# KIRKLEES METROPOLITAN COUNCIL INVESTMENT & REGENERATION SERVICE

Reference No:	<b>2026/62/91071/W</b>
Site Address:	5, Well Hill, Underbank Old Road, Holmfirth, HD9 1EG
Description:	Removal of existing front porch and erection of replacement front porch with associated alterations (within a Conservation Area)
Recommending Officer:	Joanna Rednall

### DECISION – CONDITIONAL FULL PERMISSION

General Arrangement as Proposed

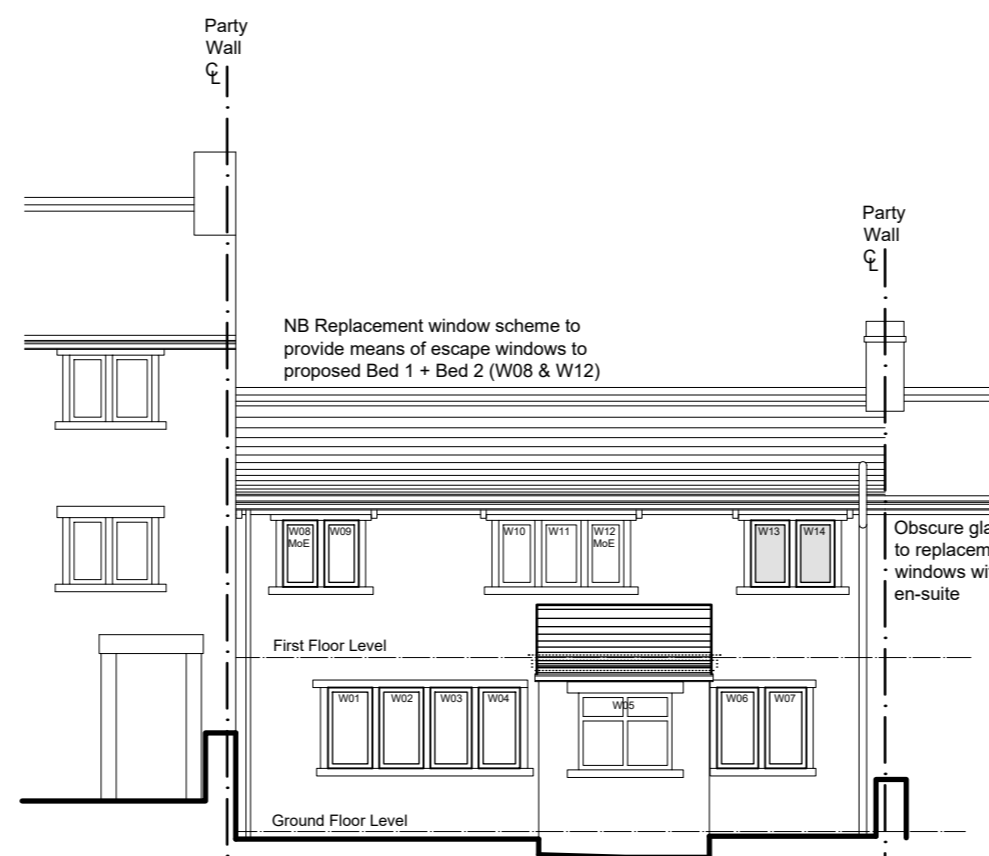
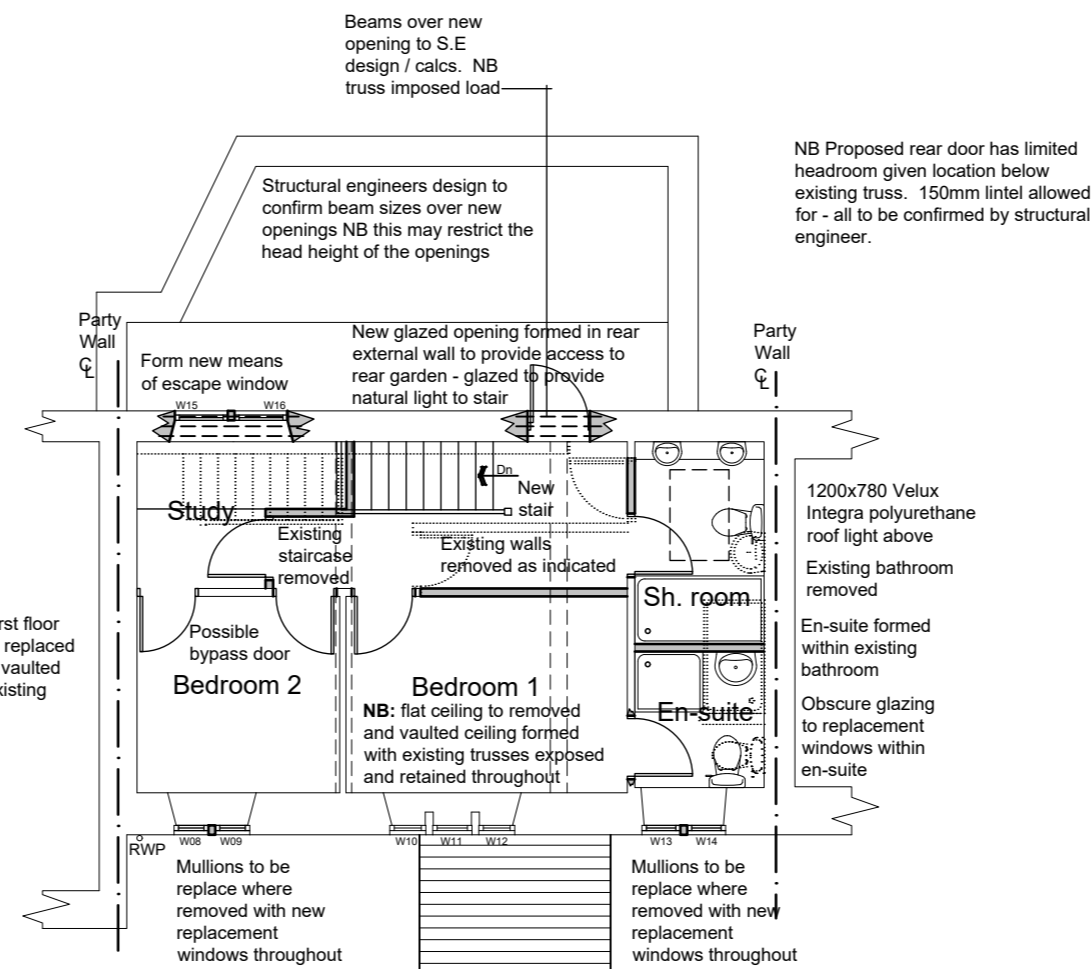
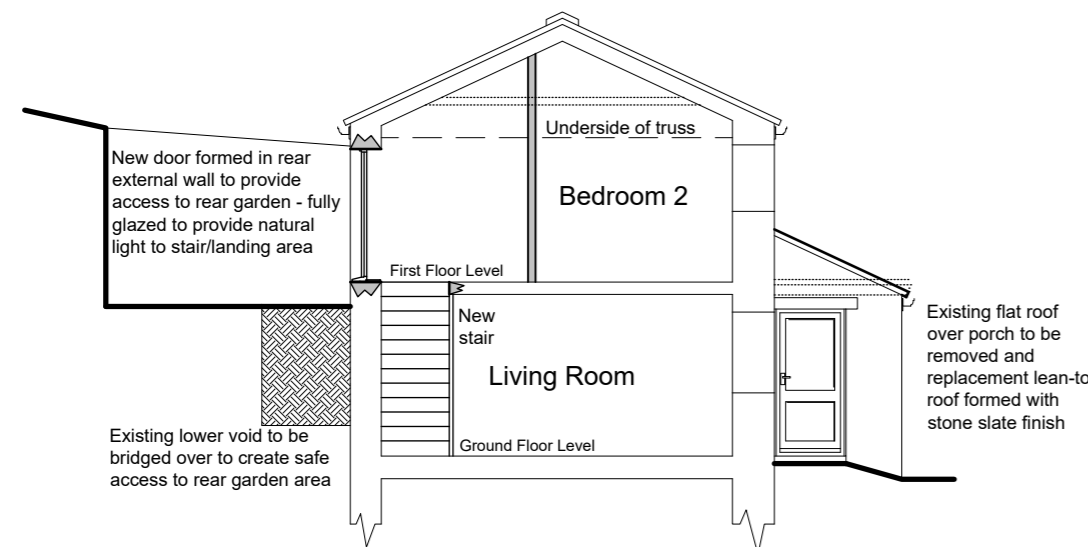
The replacement porch would retain the existing footprint while introducing a pitched, stone-slatted lean-to roof in place of the current flat-roofed structure. This alteration represents a clear improvement in terms of design quality, providing a more sympathetic and coherent addition that better reflects the form, scale and traditional materials of the host dwelling. The modest increase in ridge height is proportionate to the building and, given the property's set-back position from the highway, would not appear visually intrusive or incongruous within the street scene. This approach aligns with Policy LP24 and KDP 1 and 2, which seek to ensure extensions remain subservient and in keeping with the established character of the locality.

The replacement of uPVC windows with timber frames, together with the reinstatement of stone mullions, is considered a positive enhancement. These changes reinforce the traditional architectural character of both the building and the wider conservation area, contributing to local distinctiveness and improving the overall appearance of the frontage. No additional openings are proposed to the front elevation. A new door is proposed at first-floor level to the rear; however, this elevation is screened from public viewpoints and the change would not influence the character or appearance of the conservation area. A rooflight is also proposed to the rear. Upon the grant of permission, it is recommended for this to be conditioned to be a conservation style rooflight, in the interests of preserving the historic character of the host property and surrounding area.

The works are modest in scale and utilise materials that are consistent with the historic context of the area. They do not remove, obscure or harm any features that contribute to the significance of the Underbank Conservation Area or the adjacent Grade II Listed Building. Having regard to NPPF Paragraphs 214–216, the development is considered to result in no harm to the character, appearance or setting of the conservation area or the adjoining listed building. A condition to ensure matching roof / walling materials of construction is also recommended. Given the existing window / door materials it is considered it would be unreasonable of the LPA to insist upon use of timber, particularly in light of the improvement to the roof design in terms of materials of construction in keeping with the existing dwelling.

3. The rooflights hereby approved shall be Conservation style or similar and fitted flush to the roof plane. Glazing shall have a thickness of no more than 16mm at 4:8:4 ratio. The rooflights approved by this condition shall be retained thereafter.

4. The external materials of construction of the walls and roof of the development hereby approved shall, in all respects, match those used in the construction of the existing dwelling and be retained thereafter.
